**WELWYN HATFIELD BOROUGH COUNCIL
EXECUTIVE DIRECTOR - PLANNING, PUBLIC PROTECTION AND GOVERNANCE**

Application No: 6/2018/1603/HOUSE
Location: 78 Bell Lane Brookmans Park Hatfield AL9 7AY
Proposal: Erection of a front garage extension with pitched roof
Officer: Mr William Myers

Recommendation: Refused

CLIENT	Mr J Demetriou	Proposal	Proposed & Existing Elevations & Layouts
LOCATION	78 Bell Lane Brookmans Park AL9 7AY

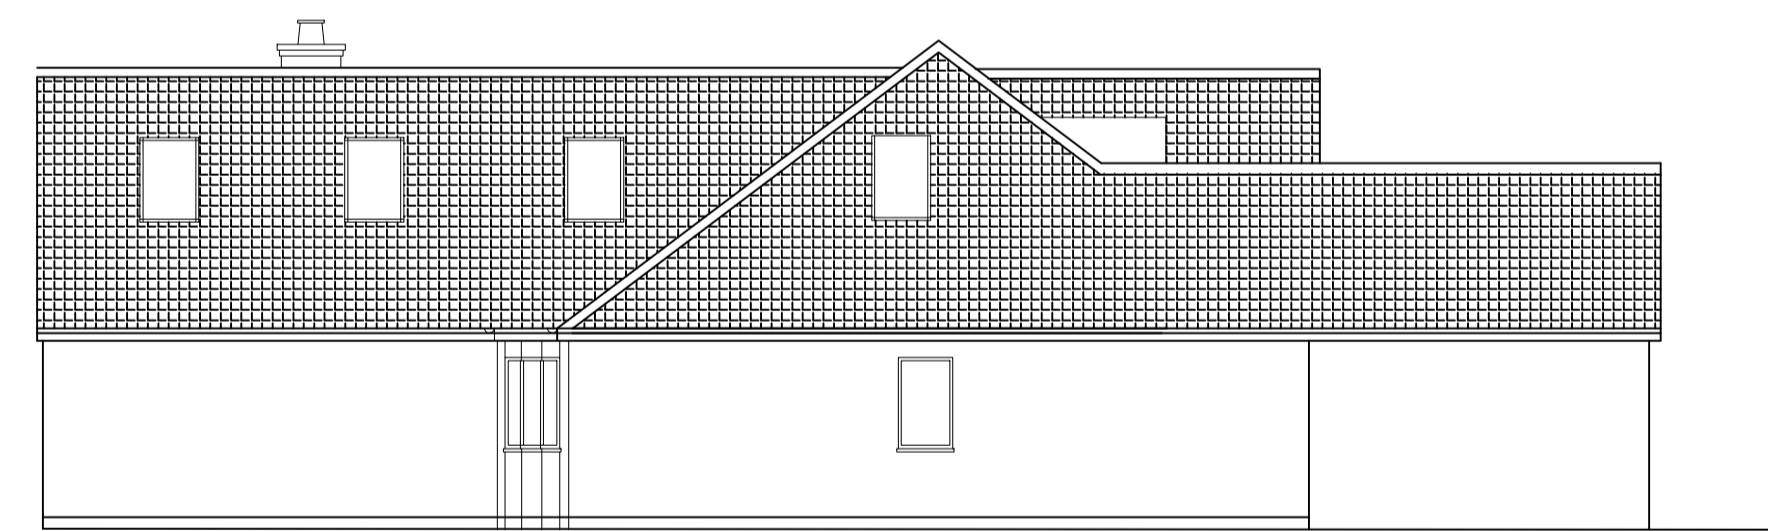
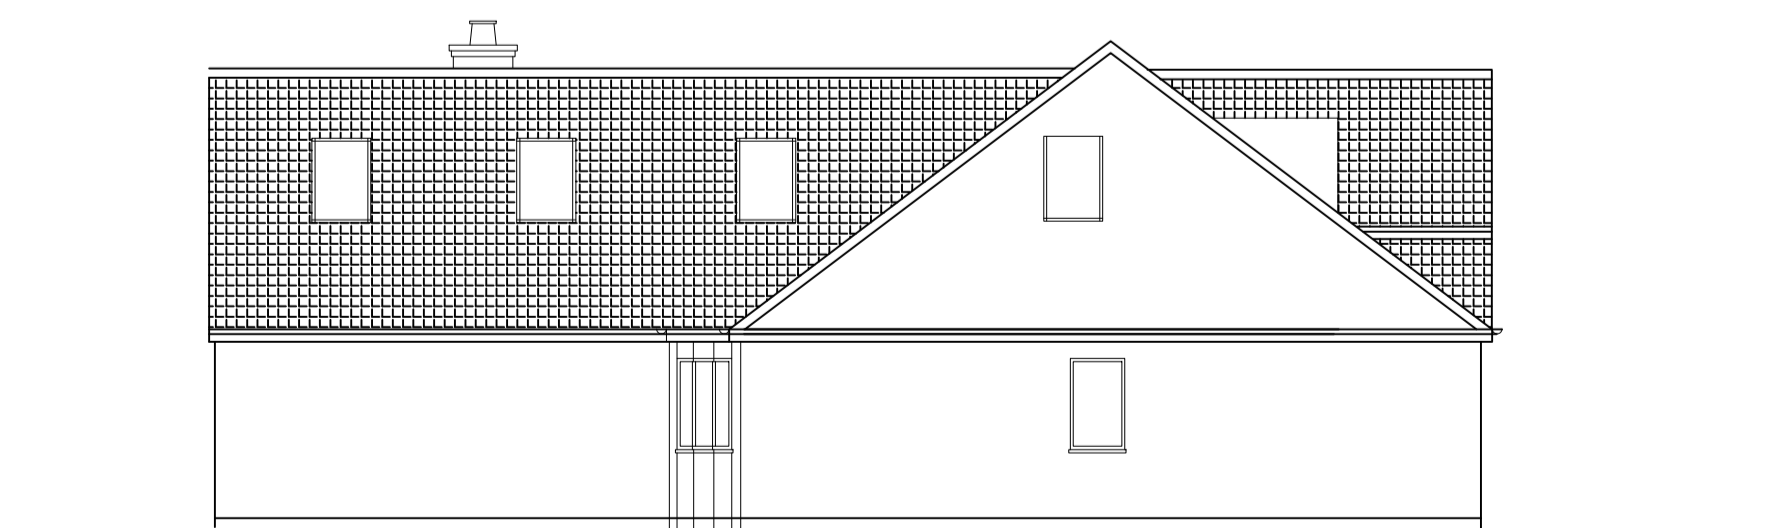
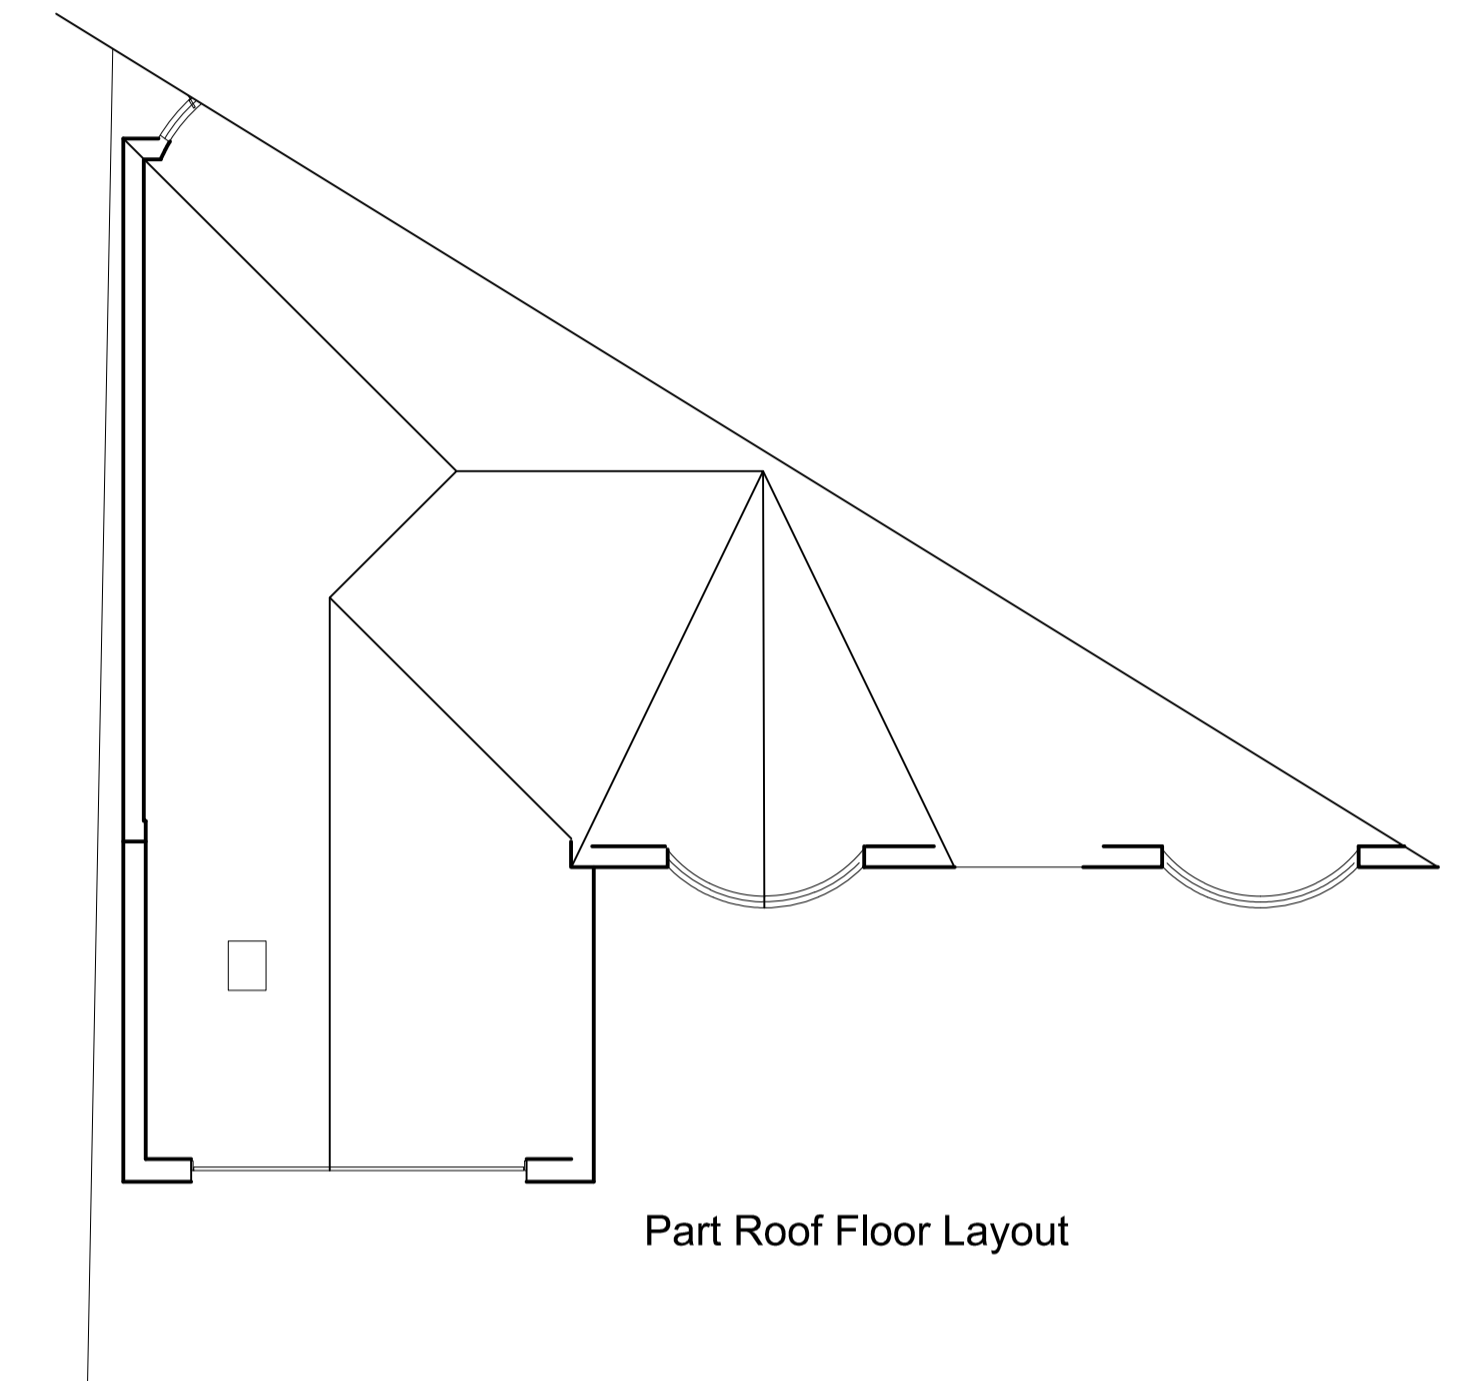
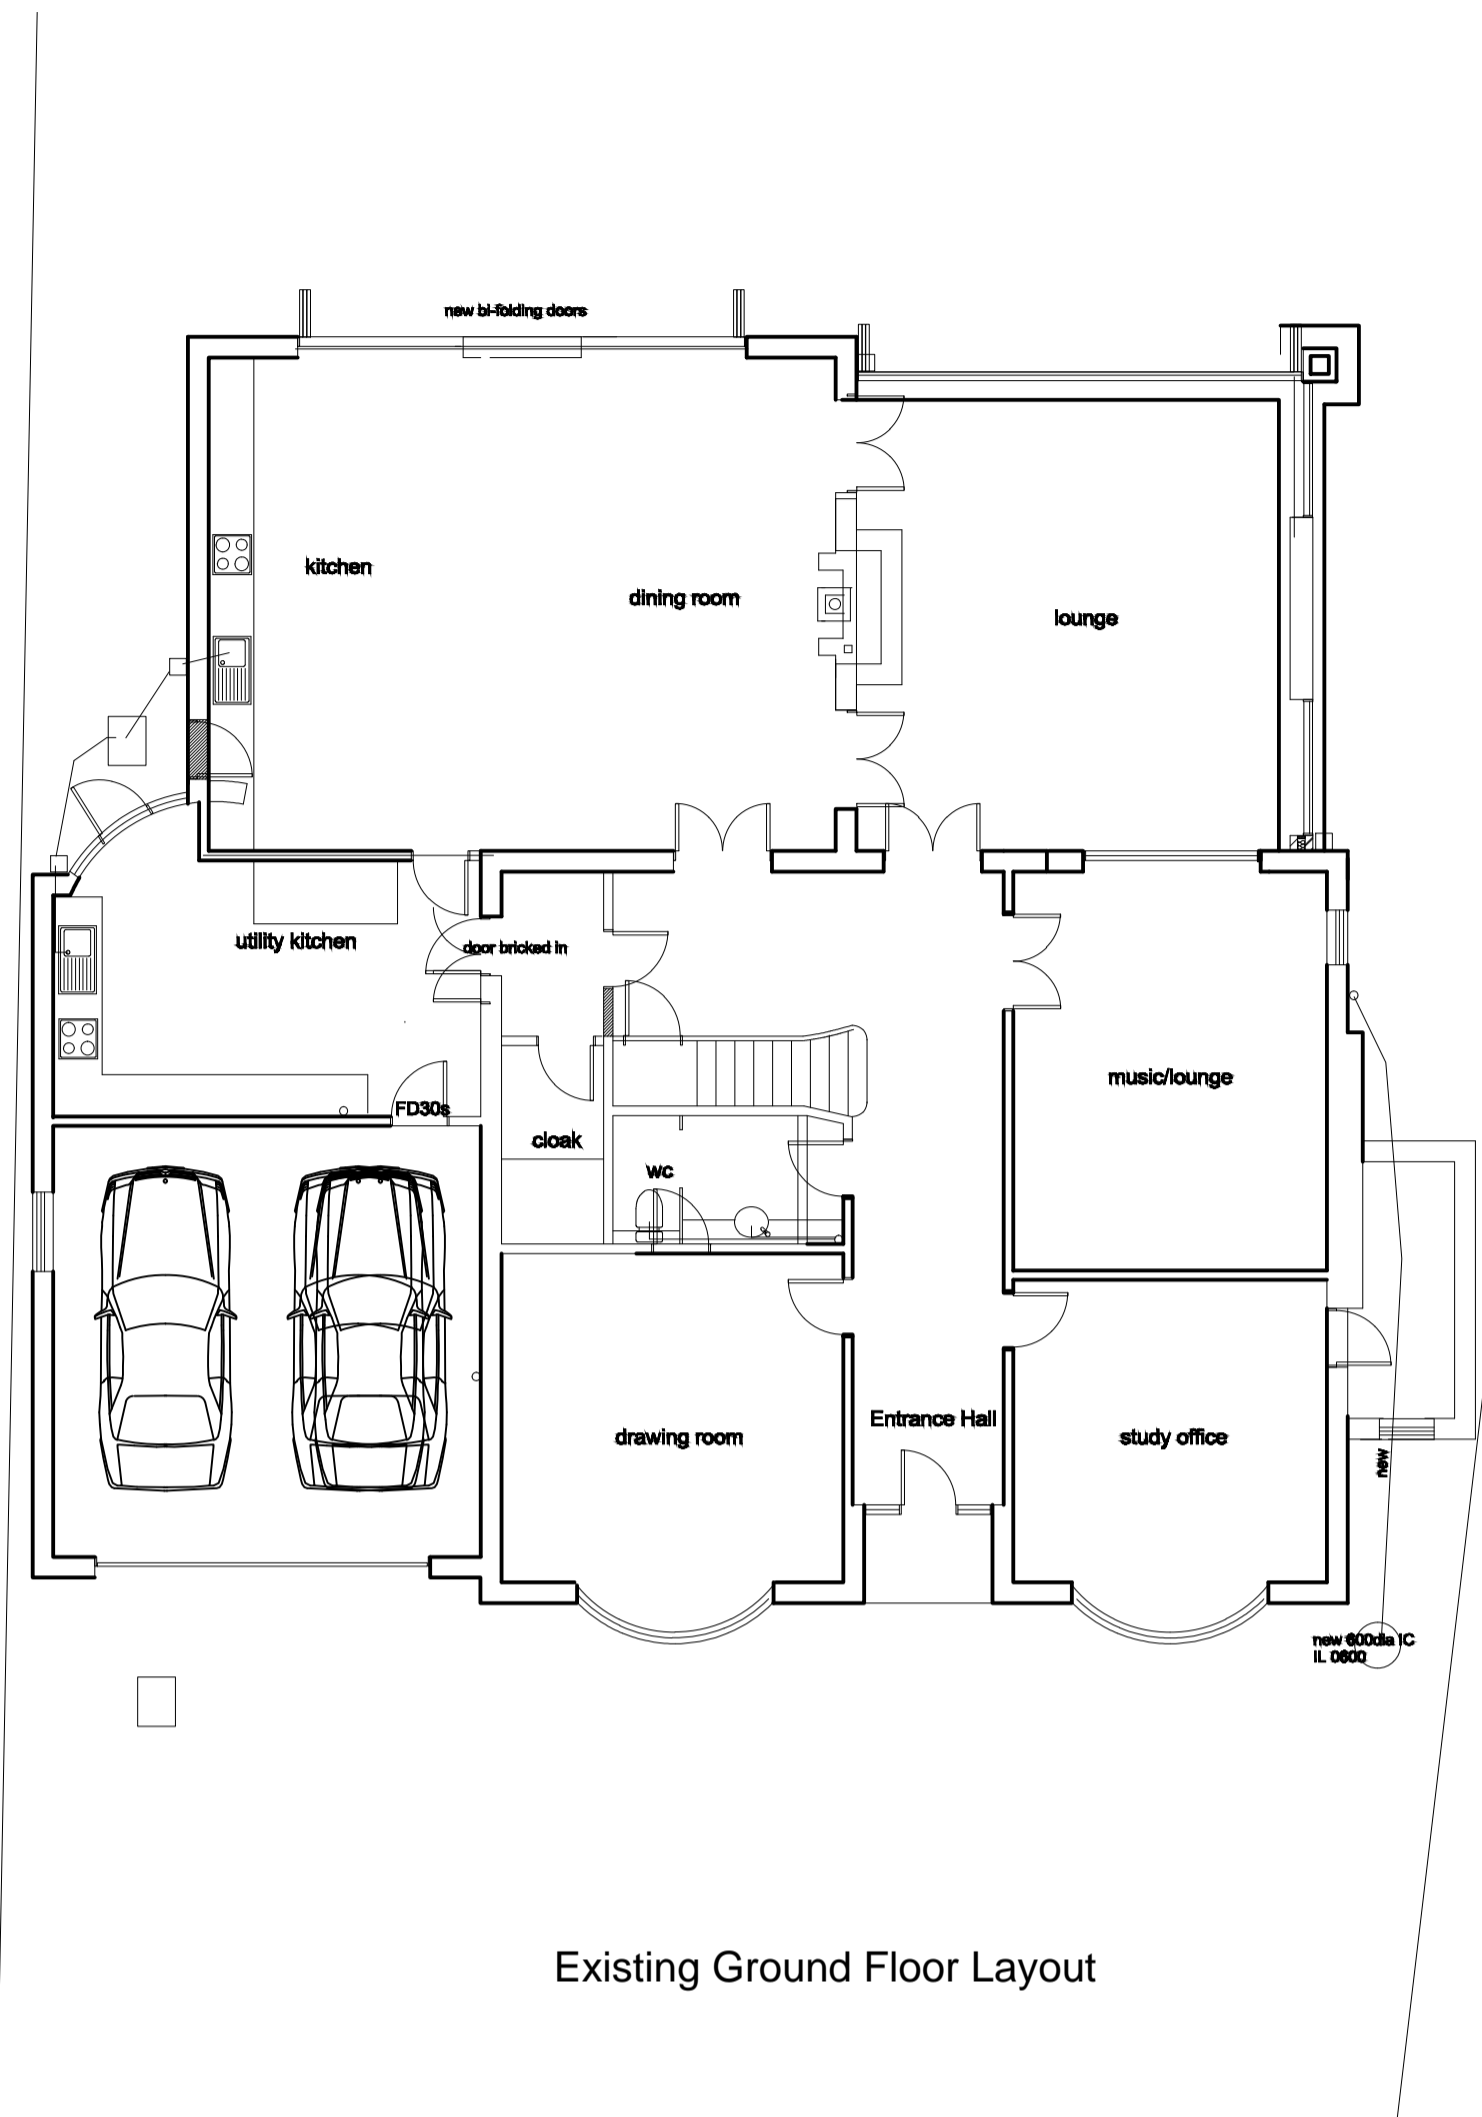
The proposed front extension would project approximately 4.2m forward of the existing front elevation of the property, with a width of approximately 6.3m. The extension would have a pitched gable end roof which would match the existing angle of the other front facing gables within the existing front elevation of the dwelling, with a height at its ridgeline of approximately 4.8m.

Although the proposed extension would not be as high as the existing two storey feature at the centre of the front elevation, it would be approximately 1.3m greater in width than this feature and its proposed roof structure would be noticeably larger than all the other existing front facing gables. This disparity in the size of the front facing gable features is most striking when the existing gable on the opposite side of the dwellinghouse is compared with the proposed gable ended projection. This is because the existing feature only has a width of approximately 4.6m compared to the proposed width the extension which would be 6.3m and would be approximately 0.3m greater in height. This feature would create a lack of symmetry when the property is viewed from the front and this would be made more noticeable by the fact that, unlike the existing front facing gable feature on the opposite side of the dwelling, the proposed roof structure would be almost touching the bottom corner of the dormer window at this side of the dwellinghouse.

It is unclear from the submitted drawings how the proposed extension would intersect with the existing projecting gable and how the roof, eaves and gutter detail along the flank elevation would be constructed. It appears that part of the roof would be flat or could possibly feature a large gully. This, together with the desire to avoid the dormer, has resulted in an off-centre and asymmetrical roof form to the proposed extension.

In addition, unlike the other front facing gable features at the front of the property, the proposed extension would project 4.2m beyond the existing front elevation of the dwellinghouse and would therefore create a dominant feature to the front of the property which would fail to adequately respect, or relate, to the existing design and appearance of the host dwelling. Furthermore, it is considered that these comparisons demonstrate that the size of the proposed extension would fail to be subordinate, or subservient, to the existing dwellinghouse.

The submitted plans do not indicate what materials the proposed extension would be constructed from but it is considered that subject to a condition being imposed that the extension be constructed out of matching materials to the existing dwellinghouse that this aspect of the proposal would not be unacceptable.

2. By reason of its size, bulk and design, the extension would fail to appear subordinate or subservient in scale, resulting in an excessive and contrived addition which would fail to adequately respect, or relate, to the existing dwelling. Furthermore, the proposed extension would create a dominant feature to the front of the property which would harm the character and appearance of the host dwelling and the surrounding area. The proposal is therefore of poor quality design which fails to comply with the National Planning Policy Framework 2018, Policies D1 and D2 of the Welwyn Hatfield District Plan 2005 and the Supplementary Design Guidance 2005.
